**WEST SUSSEX COUNTY COUNCIL
STRATEGIC PLANNING CONSULTATION**

SUBJECT: LU/244/13 - Application for approval of reserved matters following outline application LU/355/10 for the appearance, landscaping, layout and scale of 70 dwellings (including 20 affordable dwellings) within land parcel 1B. Departure from the Development Plan.

LOCATION: Land Parcel 1B, Land South Of, Courtwick Lane, Littlehampton, West Sussex

This is the second WSCC Highways and Transport response to the planning application for approval of reserved matters.

Rev.	Date	Description	Drawn	Checked
Client Bellway aap architecture				
Project Courtwick Littlehampton				
Drawing Title Parking Layout Phase 1B / 2				
Scale	1:500 @ A2		Drawn	Checked
Date	Aug 2013		BAS	DGP
Drg.No.	P802/BEL/PH1/06		File	P802-Ph 1B Layout Drawing Status
			Rev.	PLANNING

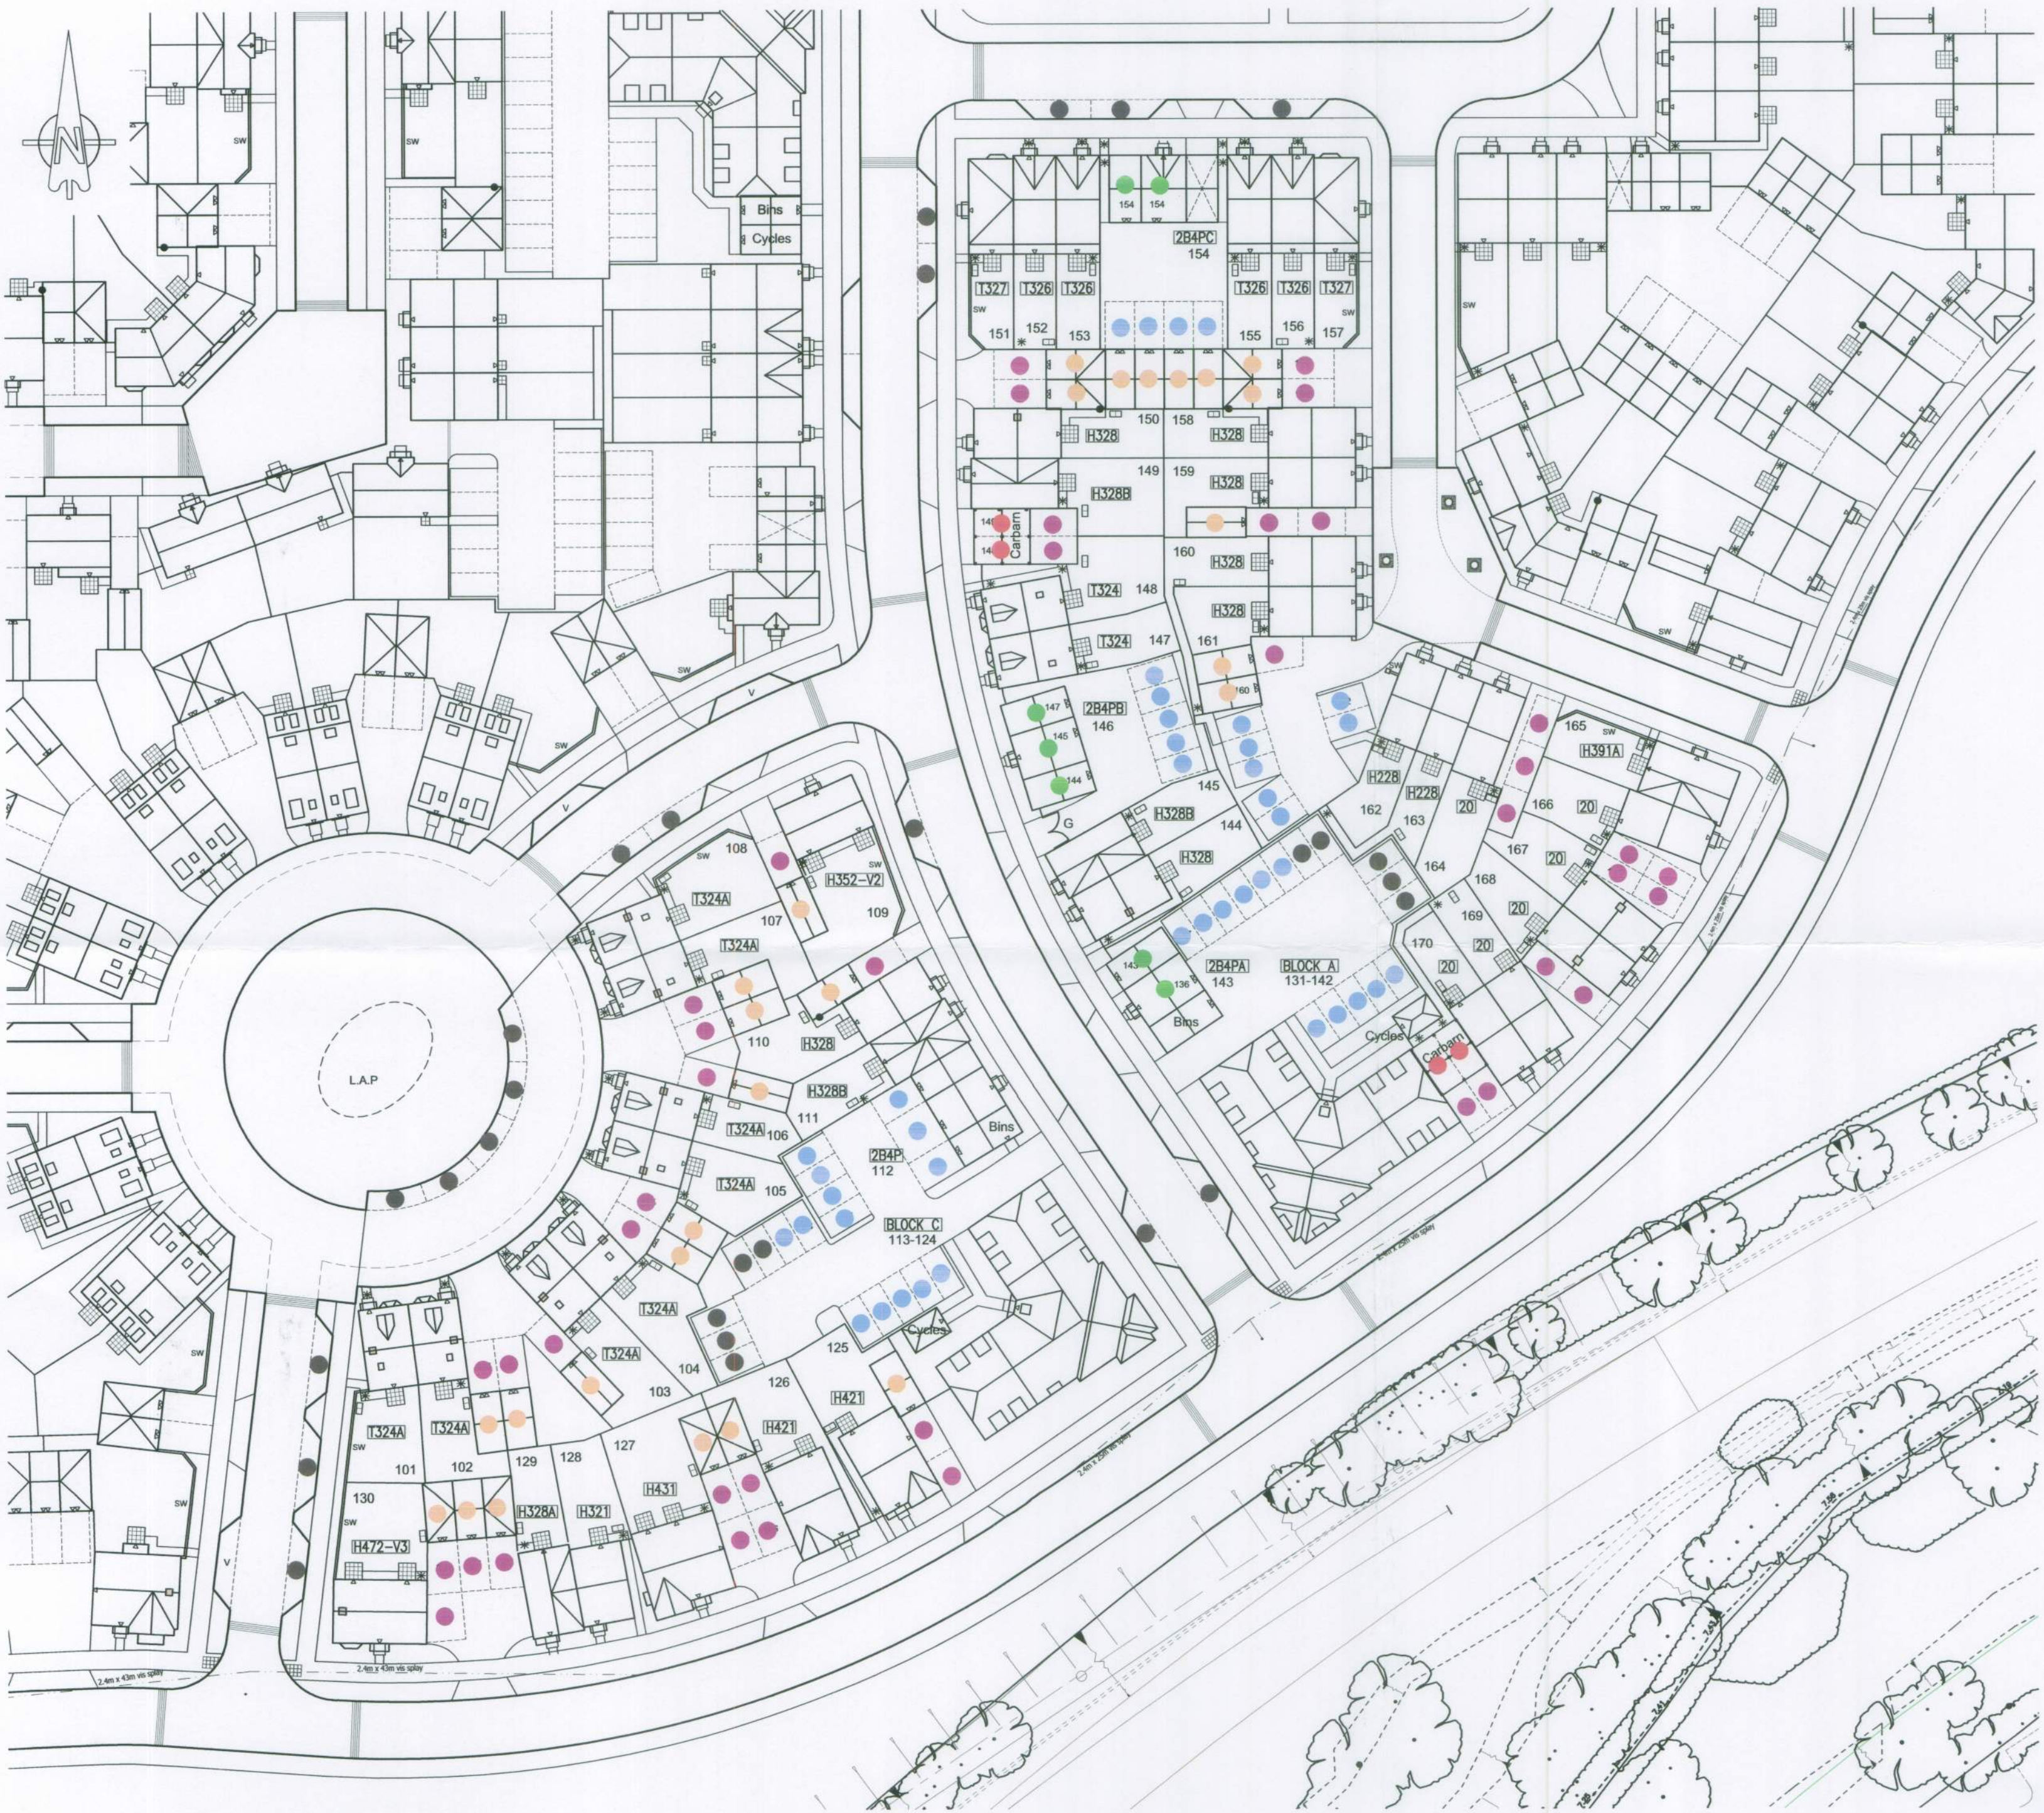
1. Sight lines at road junctions onto main spine roads to be shown at 2.4m x 43m.
2. Tactile paving to be shown at all points where footways join junctions and shared surface sections of roadway.
3. Clarification is required about the design of the eastern side of the roundabout. At present, two fixed lines are shown crossing the carriageway (adjacent to plot's 101 and 108). Please explain what these are.
4. Access to parking adjacent to plot's 161 and 162 needs to be better defined in front of No. 162. (bellmouth definition etc.)
